TOPOGRAPHIC SURVEY

6675 JICARILLA DRIVE
LOT 7, BLOCK 2, APACHE WOODS
BLACK FOREST, EL PASO COUNTY, COLORADO

DISAPPROVED
Plan Review
12/26/2019 10:53:30 AM
dsdrangel
EPC Planning & Community
Development Department

TOPOGRAPHIC SURVEY

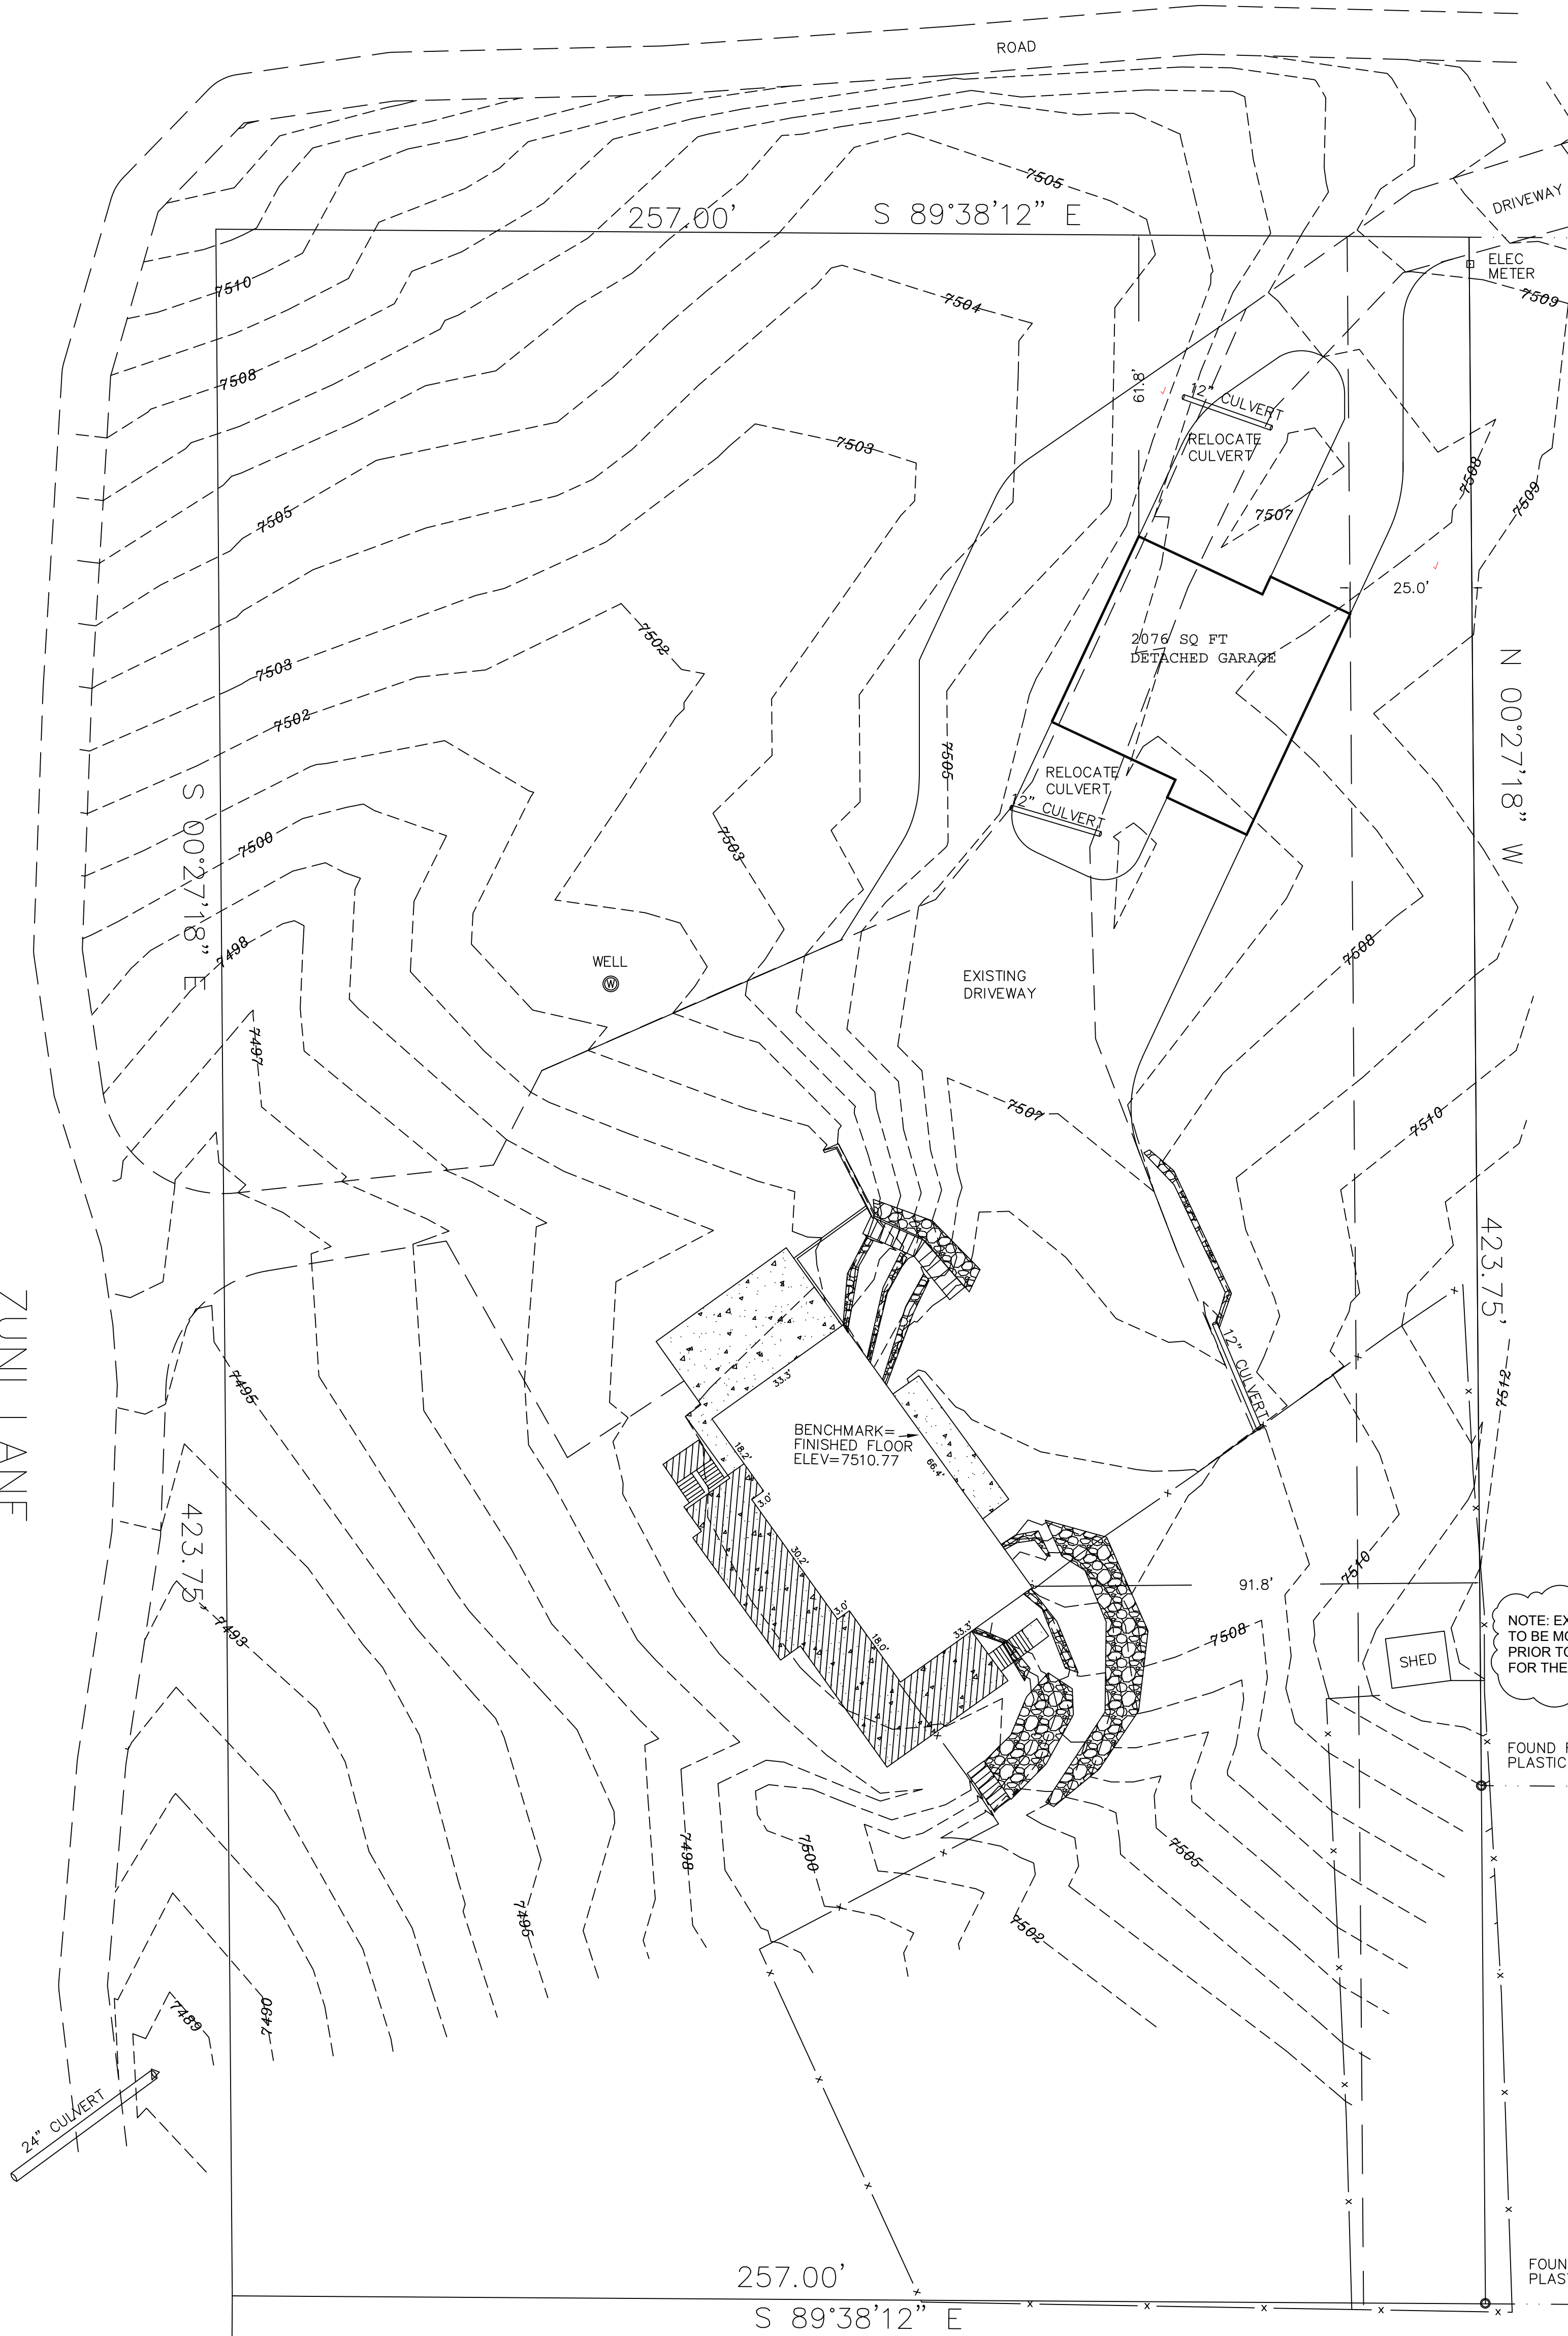
Shed is encroaching
in the side yard
setback. Contact the
planner of the day at
719-520-6300 about
BOA process for
dimensional variance.
